Adams School Redevelopment

Addendum No. 5 to Contract Documents

April 19, 2012

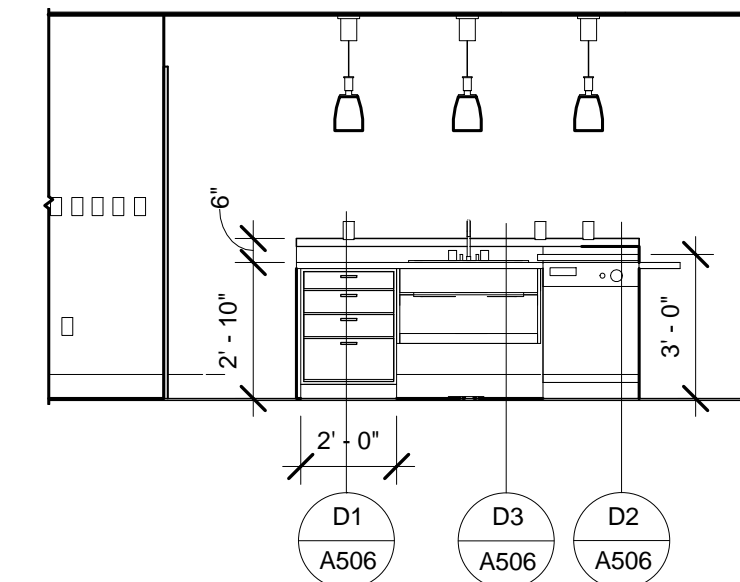
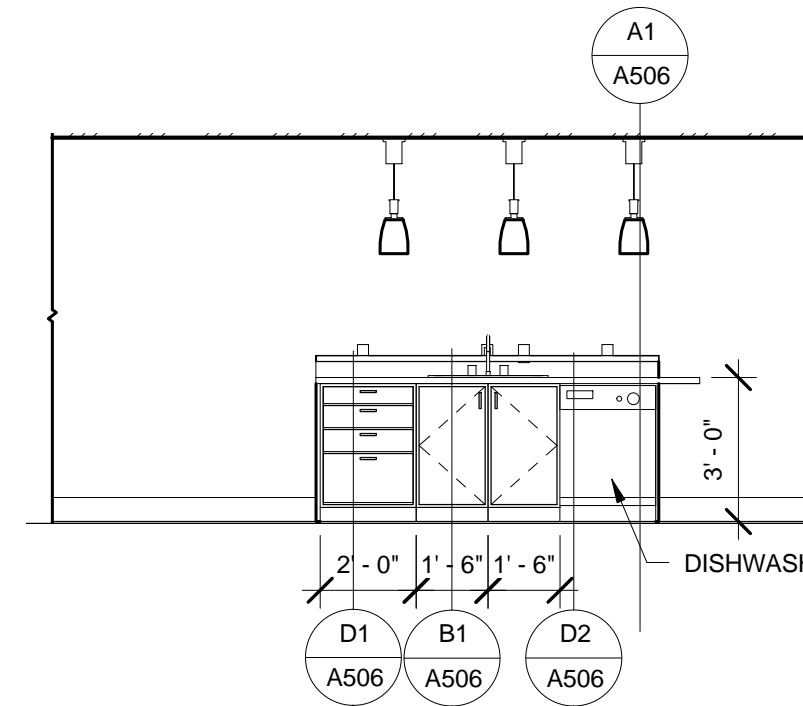
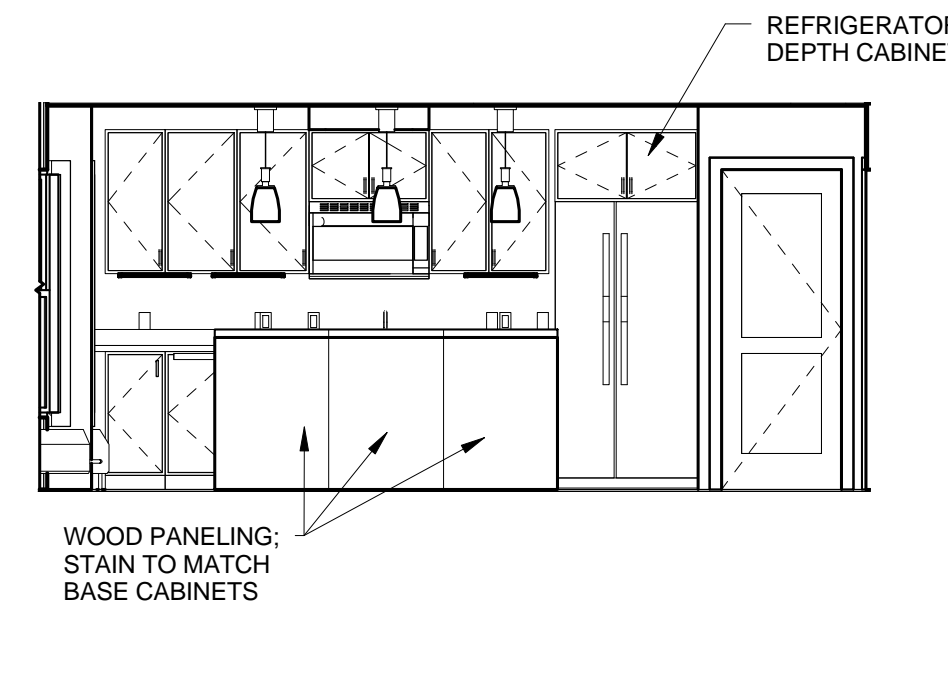
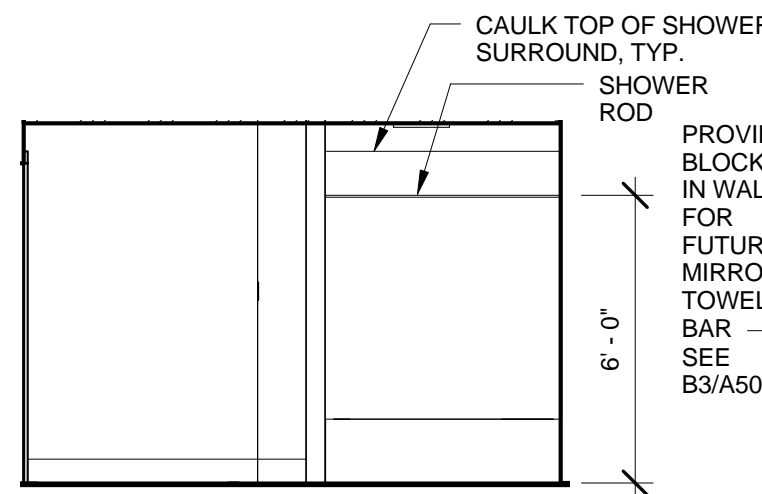
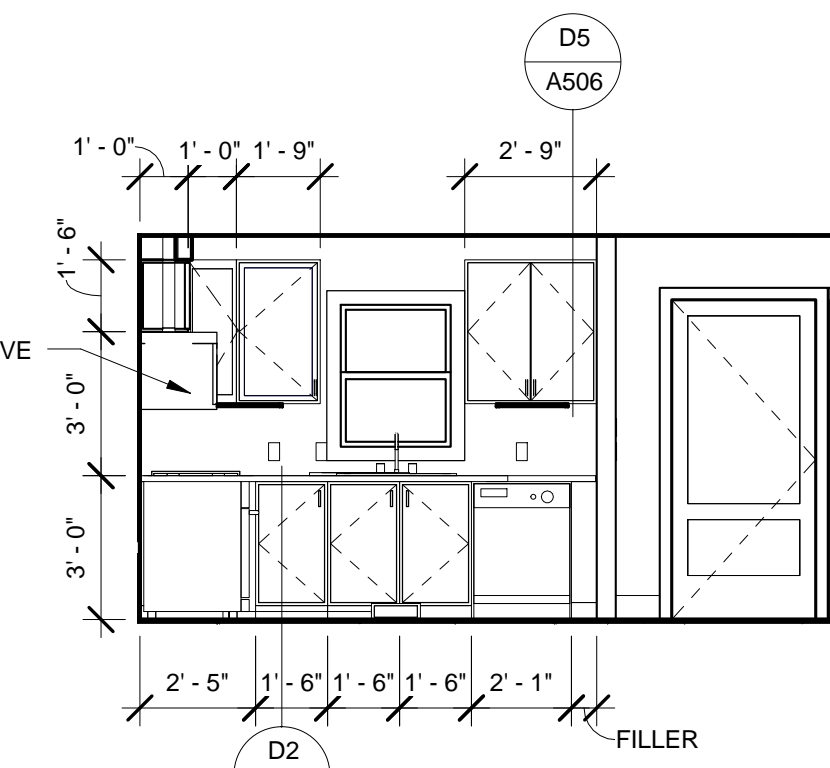
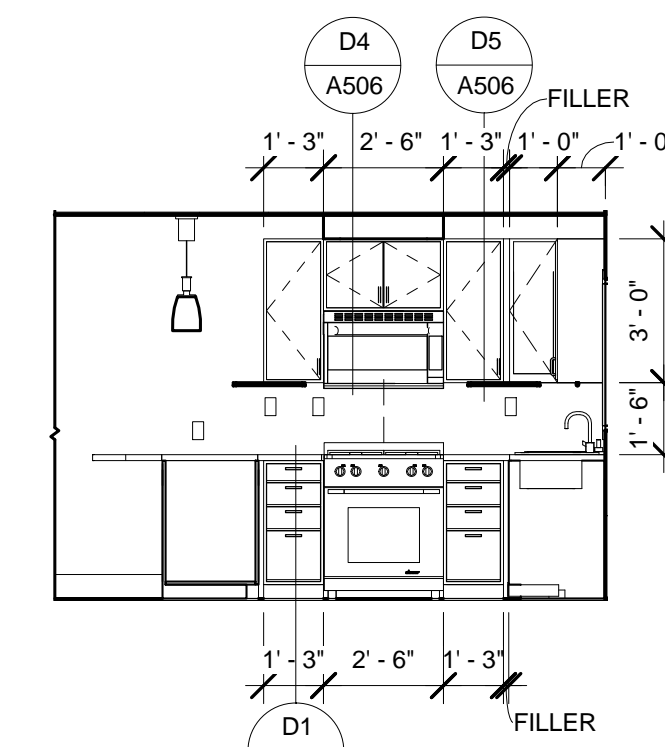
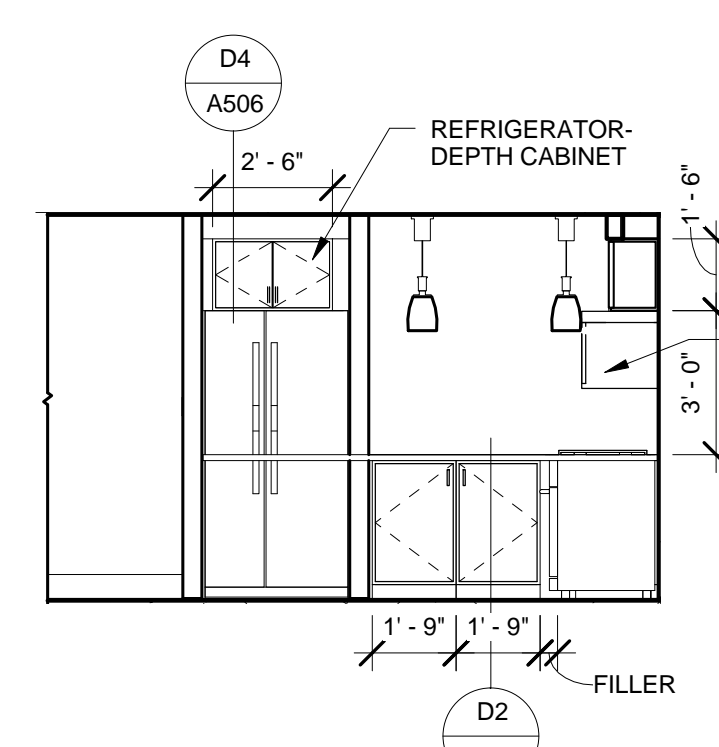
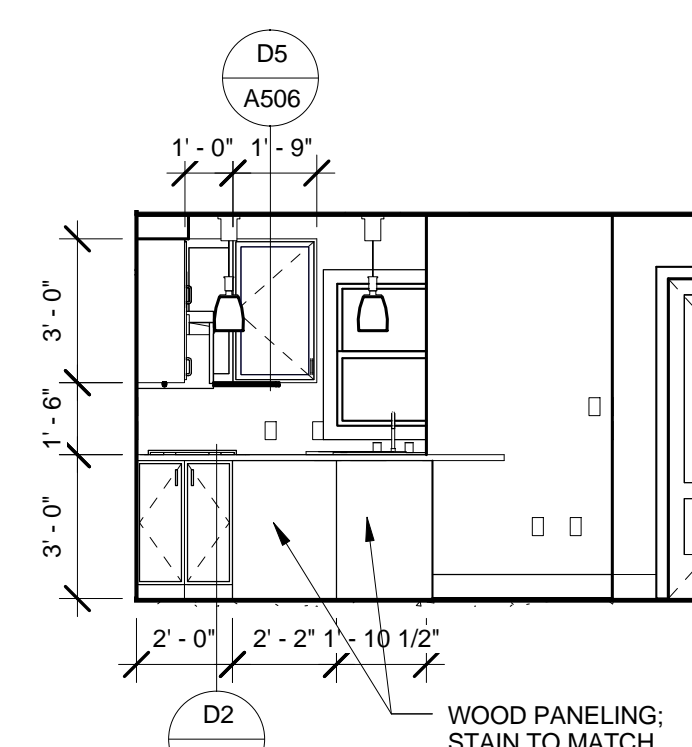
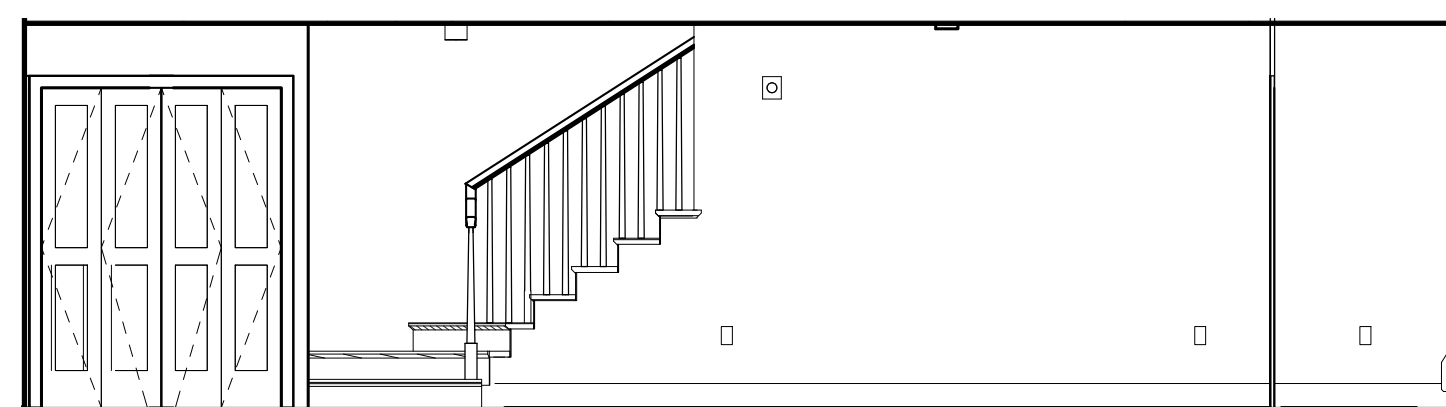
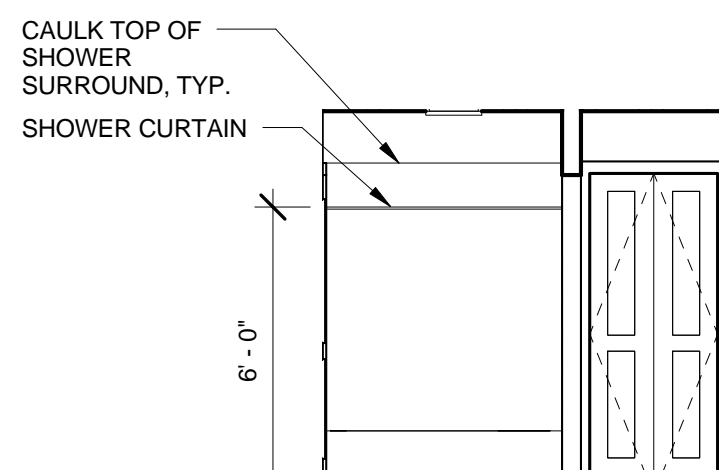
- A. Sheet A202: Modify interior elevations as shown in attached sketches SKA-2-SKA-6/Addendum 5.
- B. Detail 1/A503: CHANGE title from “Ice Dam” to “Ice Belt.”
- C. Detail A2/A504: ADD note “2x12 wood stringers, typical.”
- D. Detail B1/A504: ADD note “2x12 wood stringers, typical.”
- E. Detail C1/A504: ADD note “2x12 wood stringers, typical.”

① Copy of BATH - 3BR UNIT Ref: 22/A202
 1/4" = 1'-0"

② Copy of BATH-3BR UNIT Ref: 24/A202
 1/4" = 1'-0"

① Copy of POWDER - 2BR UNIT Ref: 20/A202_
 1/4" = 1'-0"

② Copy of TYPICAL BATH - 3BR UNIT Ref: 11/A202
 1/4" = 1'-0"

1 Copy of KITCHEN ISLAND- 2BR UNIT Ref: 3/A202
 1/4" = 1'-0"

2 Copy of TYPICAL KITCHEN - 2BR UNIT Ref: 1/A202
 1/4" = 1'-0"

① Copy of KITCHEN - 3BR UNIT
1/4" = 1'-0"

② Copy of TYPICAL KITCHEN- 3BR UNIT
1/4" = 1'-0"

① Copy of KITCHEN/LIVING - 3BR UNIT
 1/4" = 1'-0"

**S1.1**

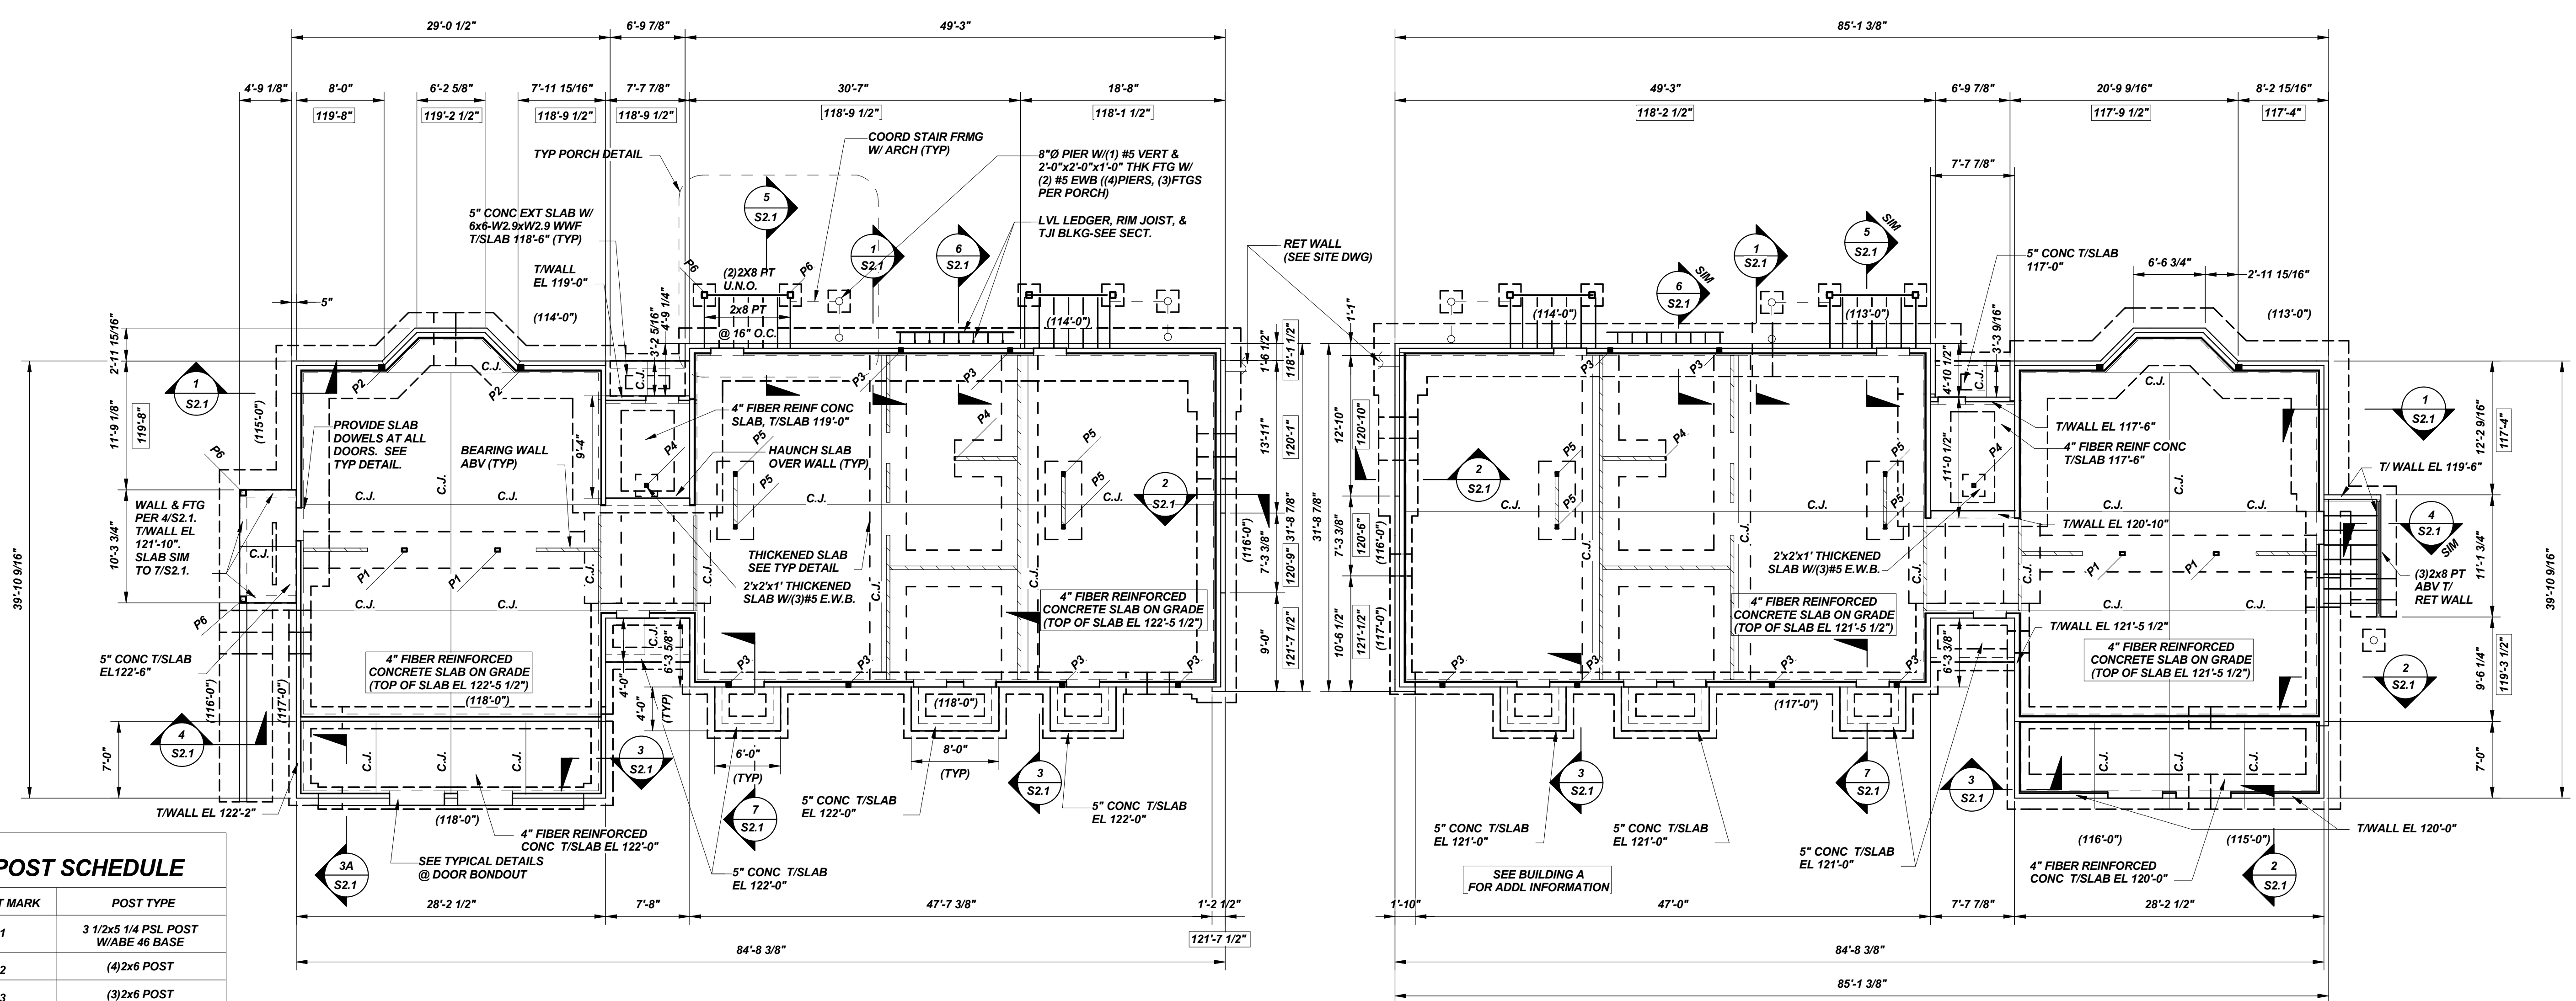
- A. Sheet S1.1: Modify as shown in attached sketch SKS-2/Addendum 5.
- B. Sheet S1.2: Modify as shown in attached sketch SKS-2/Addendum 5.

SKS-2 4/19/12 ADDENDUM 5
REVISIONS TO EXT. SLAB DIMENSIONS
PAGE 1 OF 2
